Online Comment

Application	H08-0744-21
Location	25A High Street Gosberton Spalding PE11 4NW
Proposal	Residential development & associated works - outline approval H08-0678-16

Name	Angela Doherty
Address	Housing Strategy

Date Submitted	26-07-21
For/Against	Comments

L-WOO-074-LP

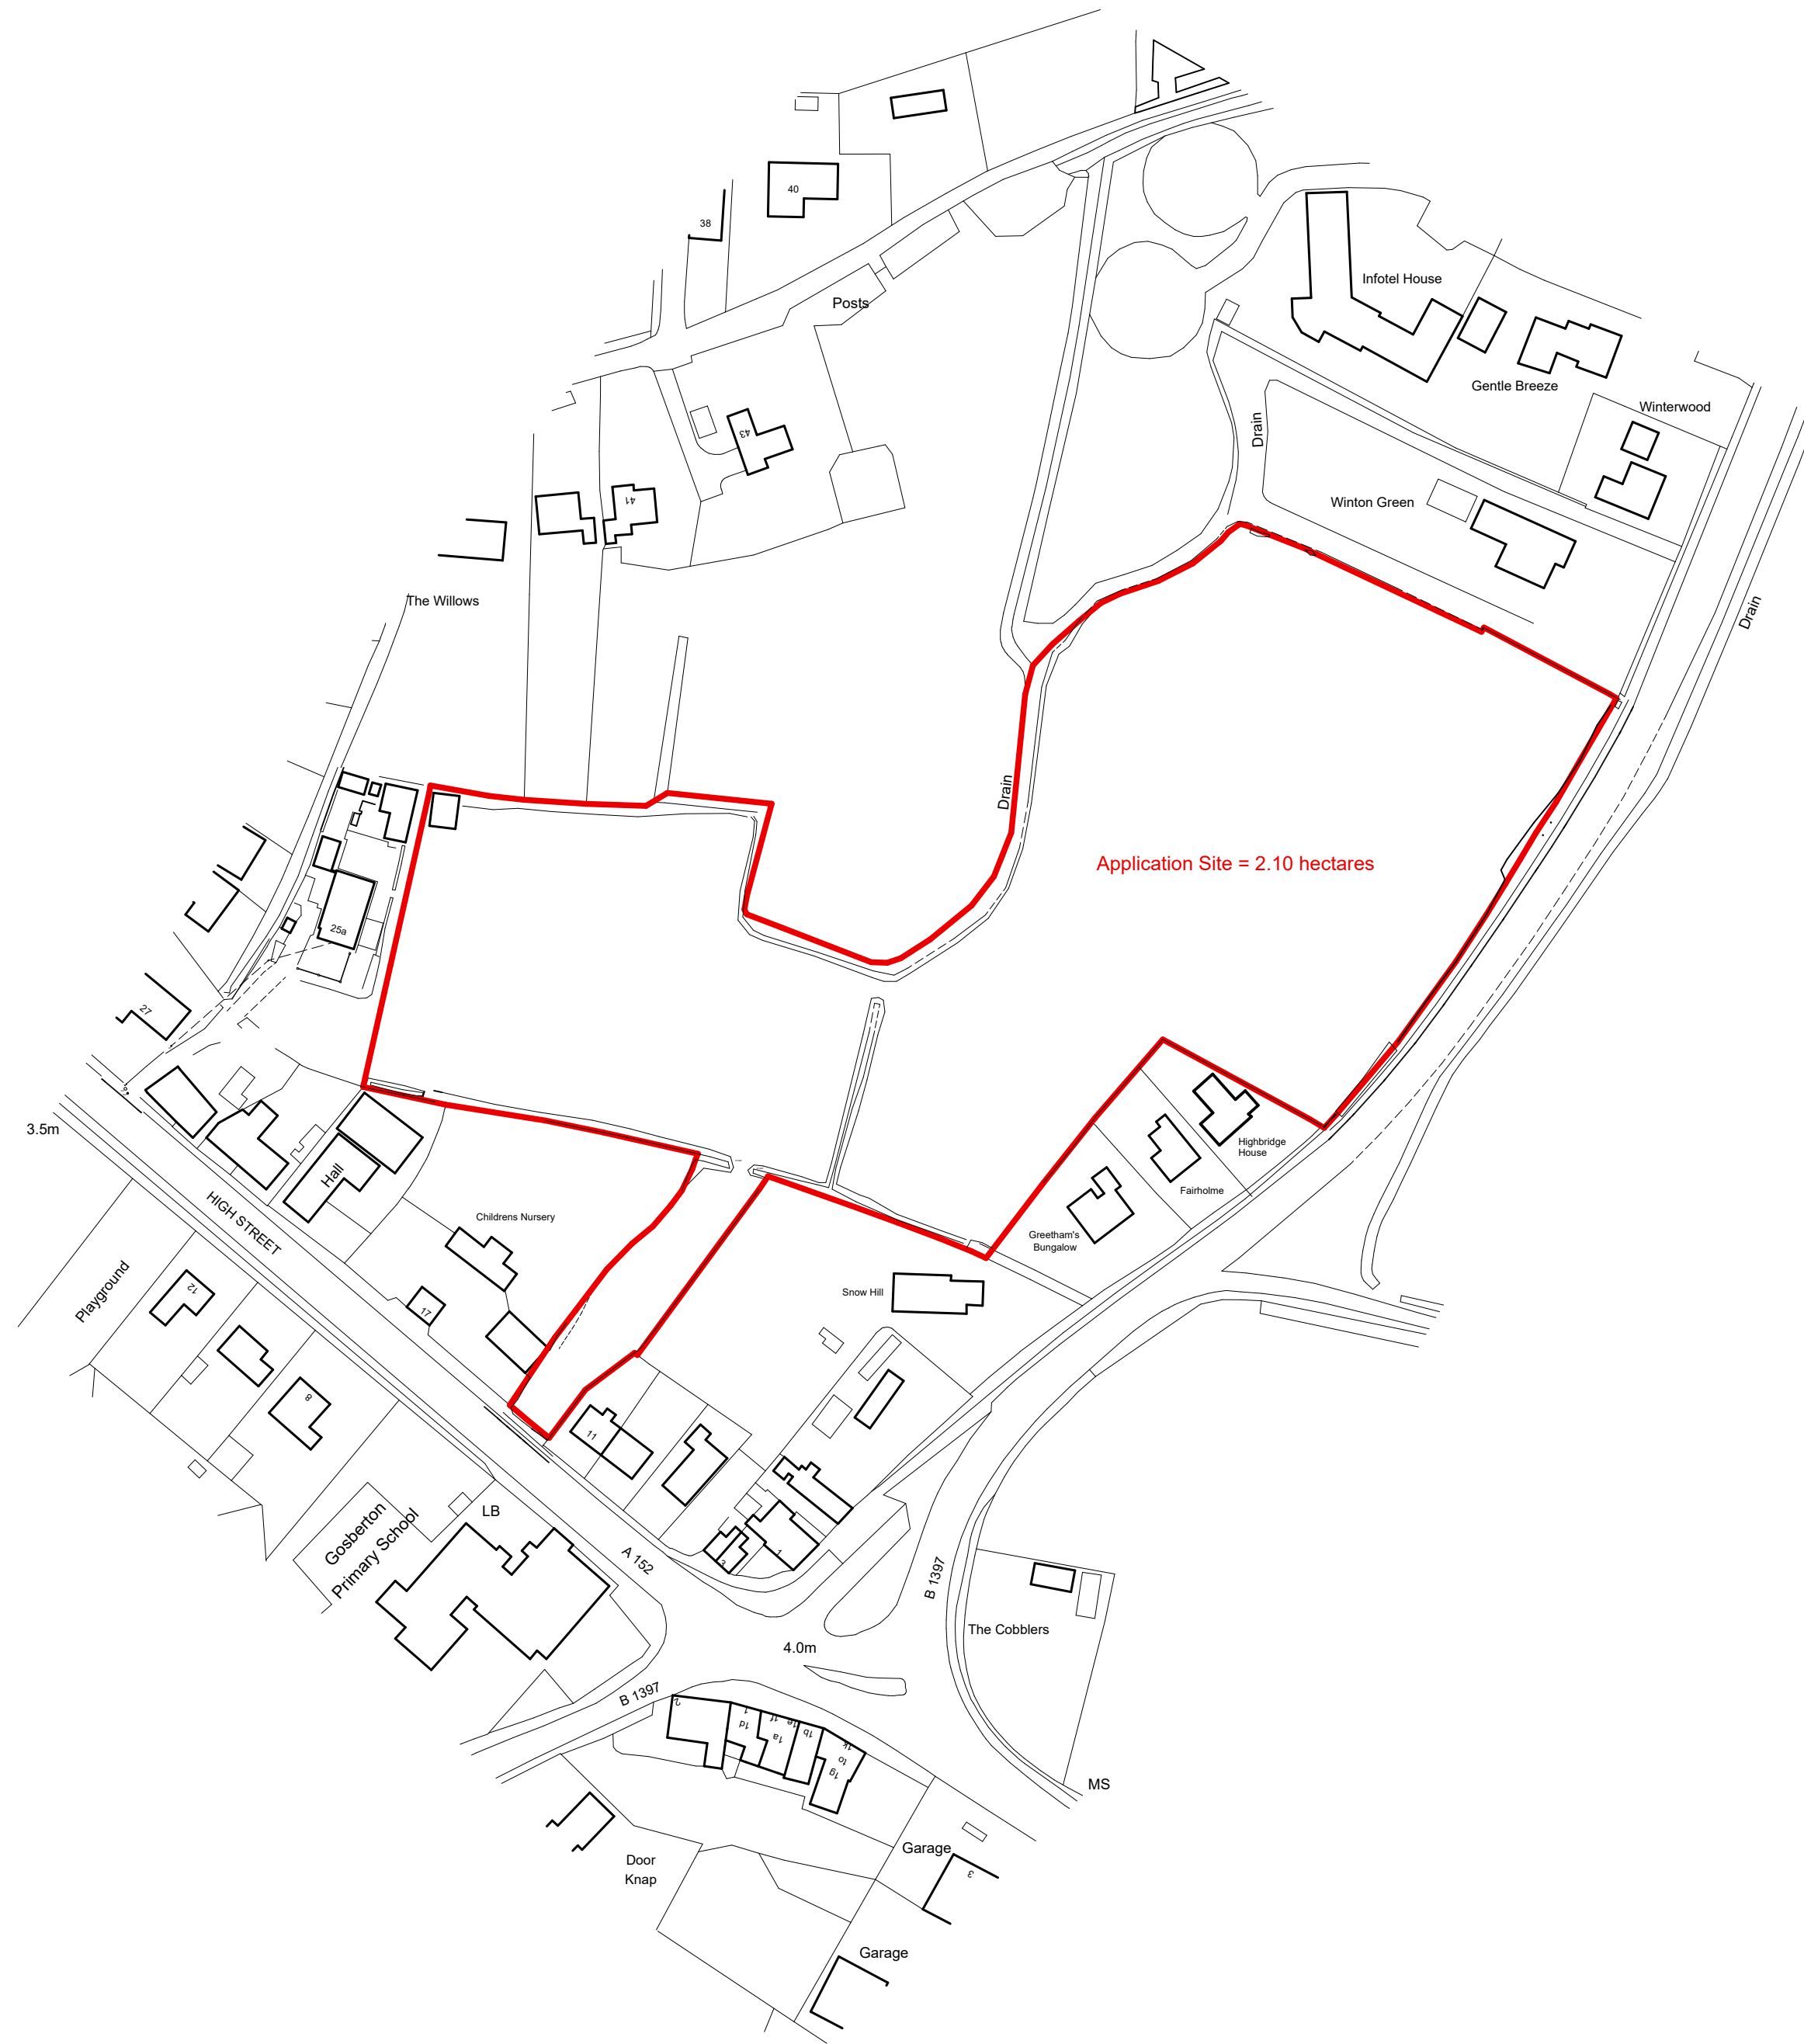
Within this Reserved Matters application the applicant states in Plan L-WOO-074-LP that plots 27-36 are proposed for the affordable housing, comprising 4 x 2 bed houses and 6 x 3 bed houses. This equates to 21.74% of the development, satisfying the s106 Agreement. For these 10 affordable dwellings the applicant has not distinguished the tenure split, however the s106 Agreement sets out that 60% will be for rented housing and 40% for intermediate.

Policy 17: Providing a Mix of Housing in the Local Plan encourages a mix of house types and sizes to meet a range of needs. To best meet housing needs the applicant should consider amending the plans to deliver 2 x 1 bedroom houses, 3 x 2 bedroom houses and 1 x 3 bedroom house as rented housing and 2 x 2 bedroom and 2 x 3 bedroom houses or bungalows as shared ownership.
